REVIEW OF KEY MINING ISSUES DRAYTON SOUTH COAL PROJECT 2015

September 2015

Report prepared for Darley Australia and Coolmore Australia

Review of Key Mining Issues Relating To The Drayton South Coal Project EIS 2015

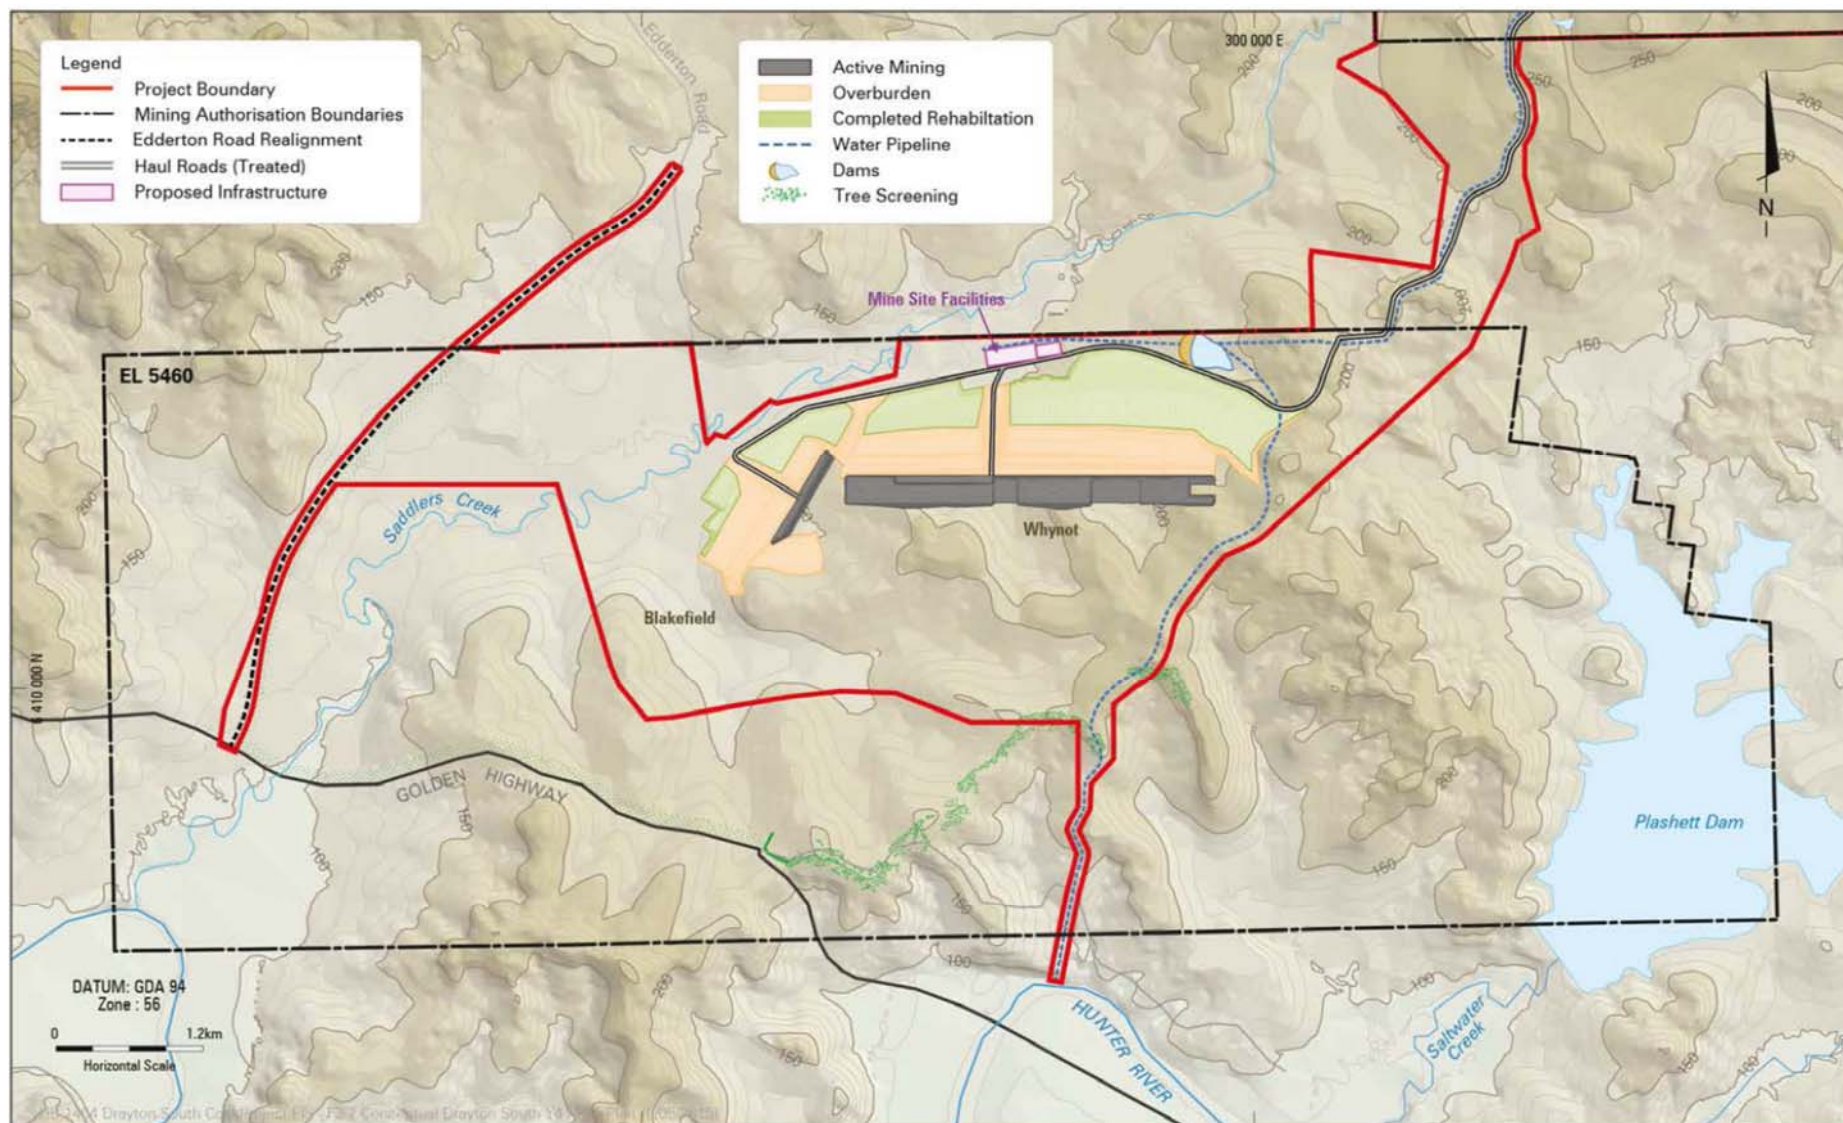
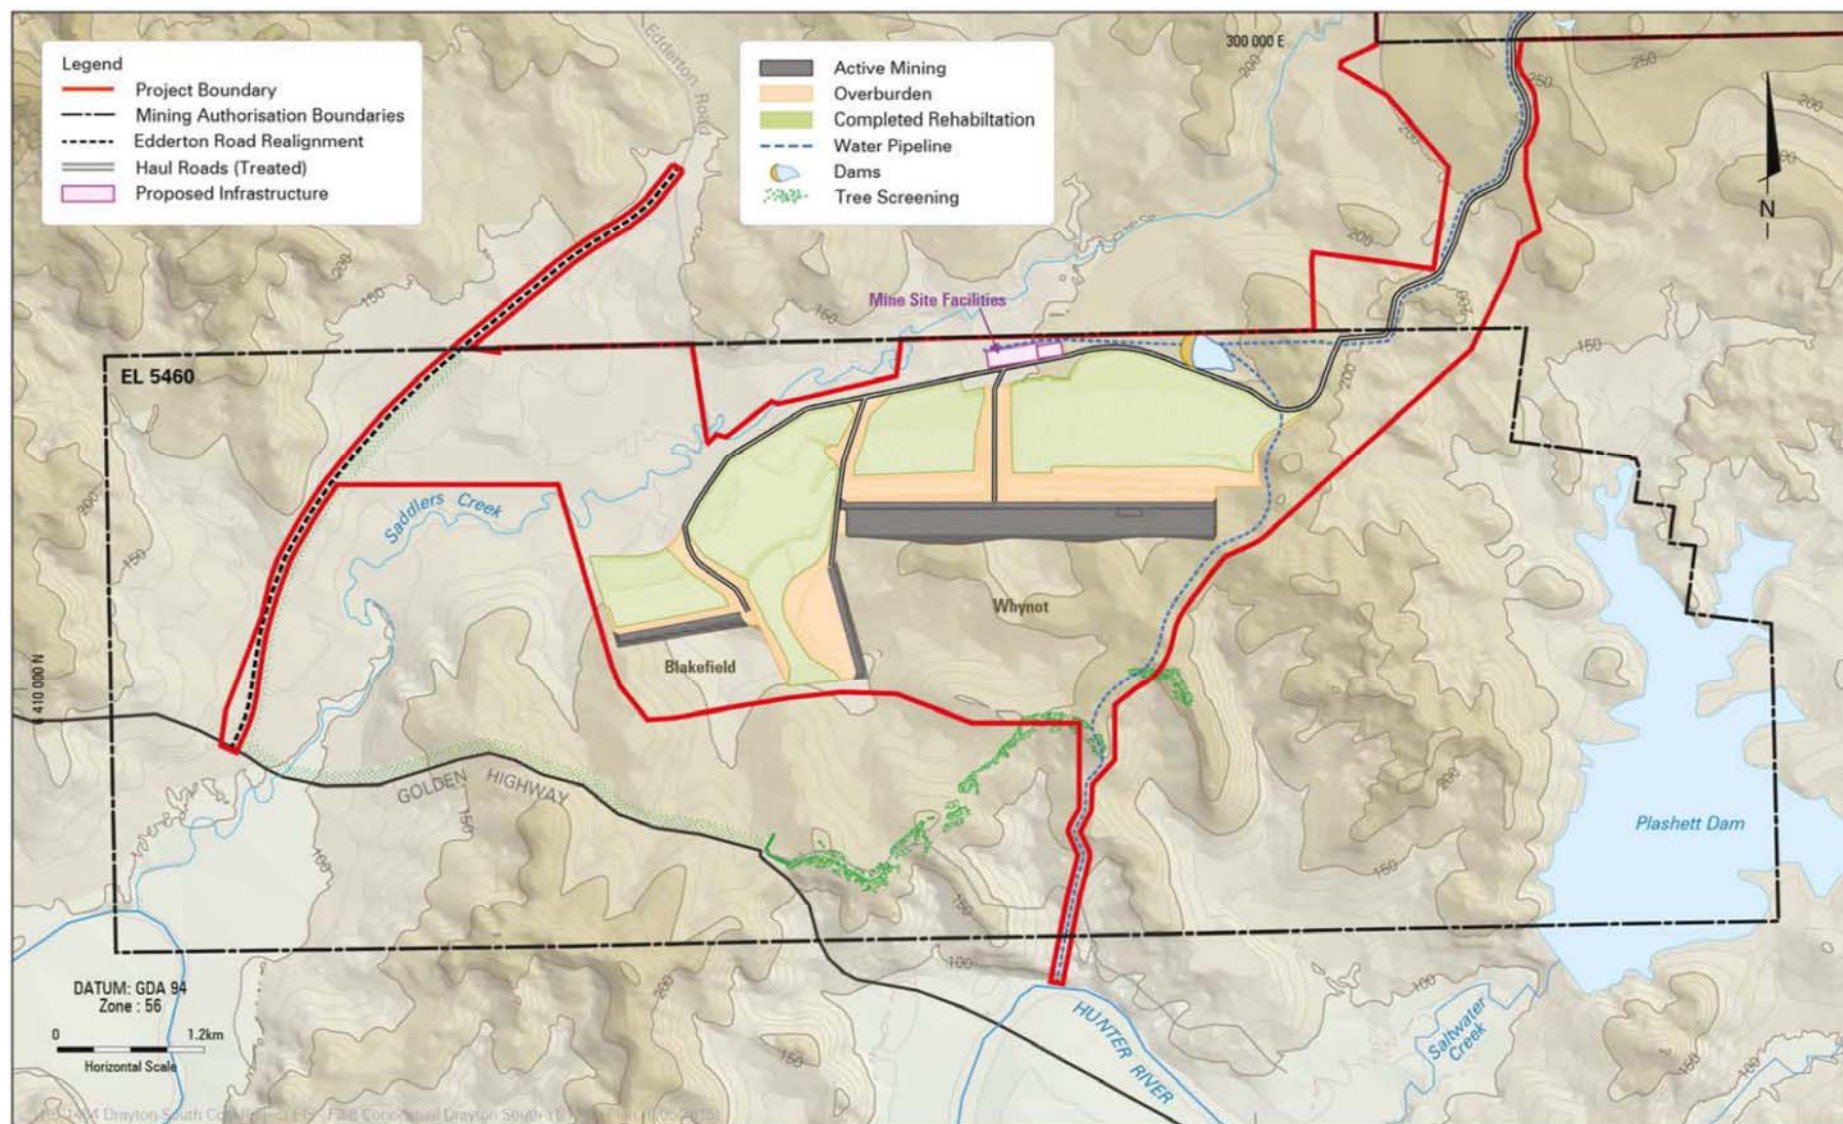
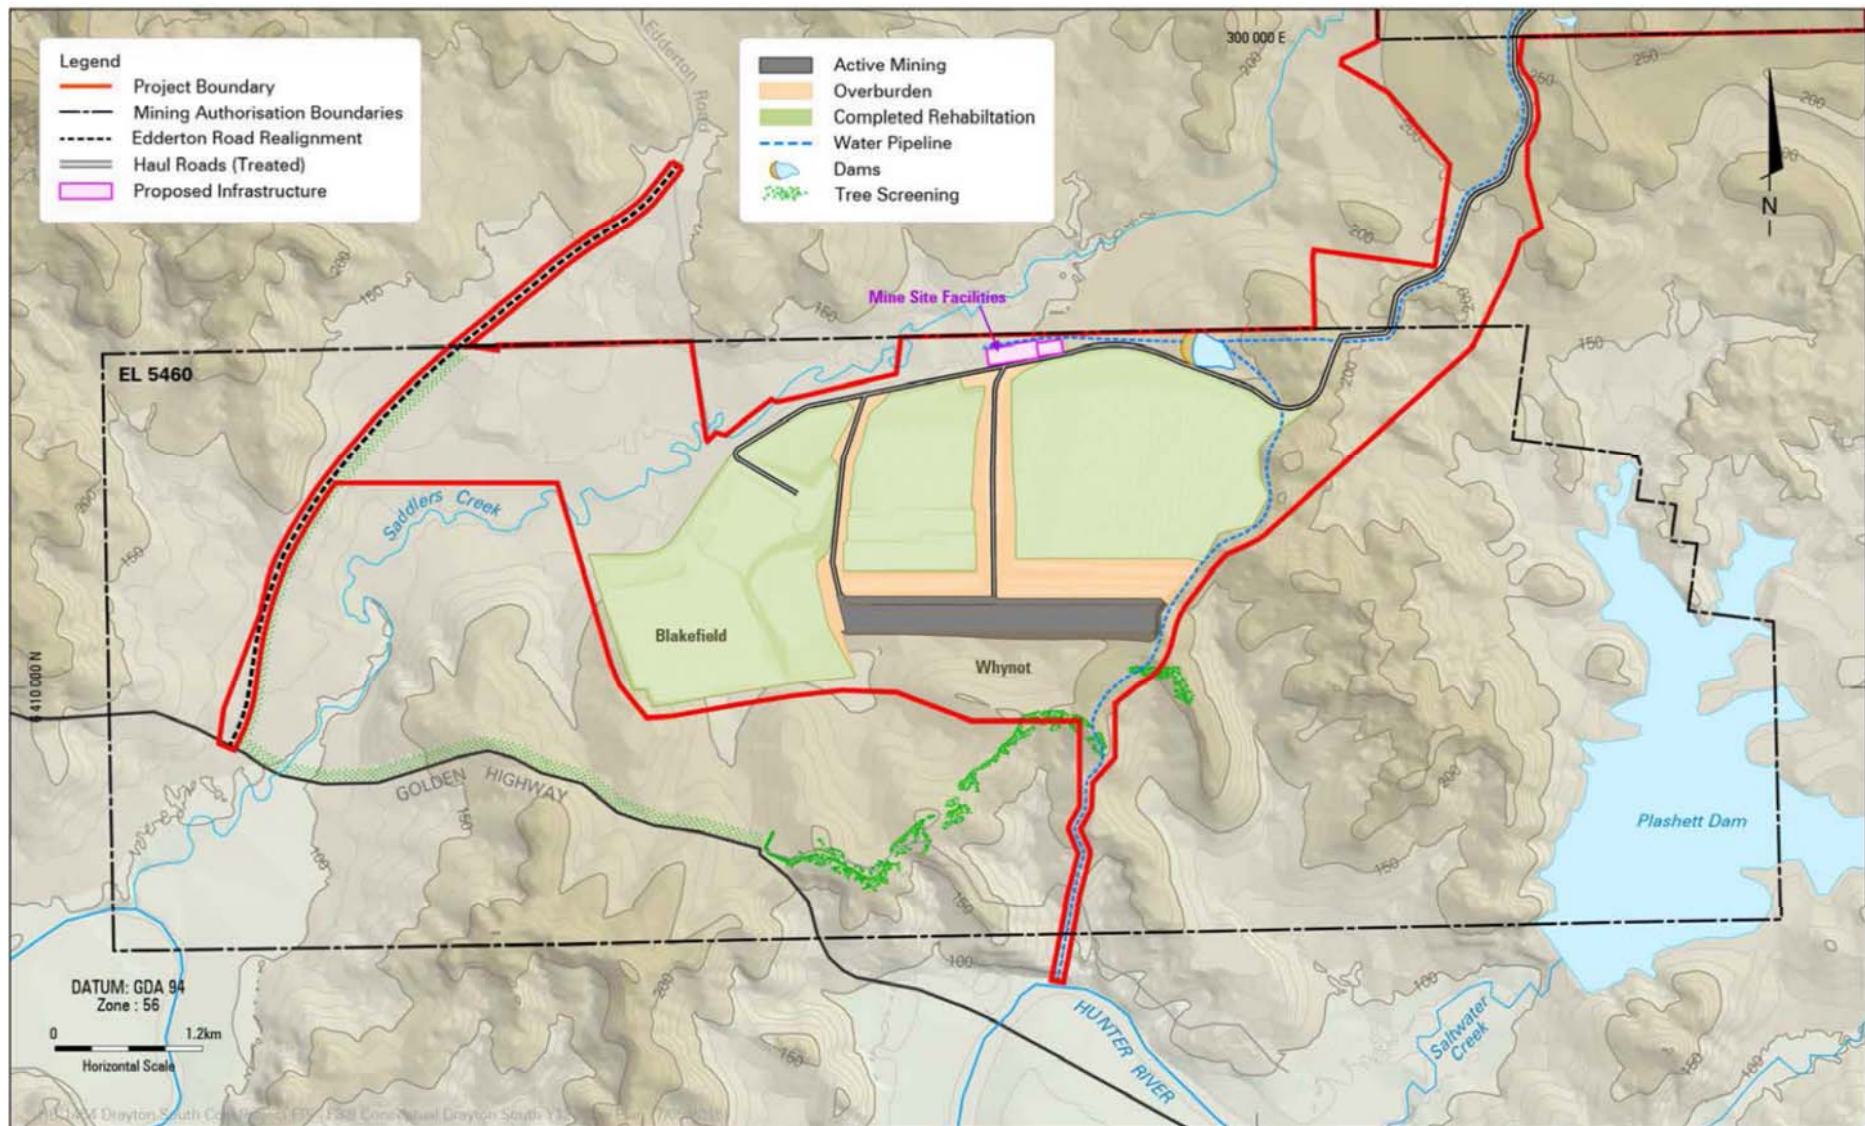
The life of mine total ROM coal shown in the Production Schedule Summary is 73.446 M ROM tonnes.¹ This is reproduced as Figure 3 above. The dragline waste volumes shown in Year 1 and Year 2 of the Schedule and Profile must be from Drayton Mine based on the information provided in the EIS that the dragline does not relocate to the new Drayton South area (Whynot Pit) until Year 3.

Issue 2b: Incorrect data in the Air Quality Model coal and waste Production Schedule

The above table shows that the Total Waste (Mbcm) for each pit is mathematically wrong and that the Total Waste (Mbcm) overall is also mathematically wrong. It understates the total waste volumes in each year when compared to the EIS Production Schedule Summary as follows:

If this error has been carried through into the air quality modelling the air quality impacts may well have been understated due to the incorrect lower waste movement volumes used and the actual impacts to air quality could be worse than predicted.
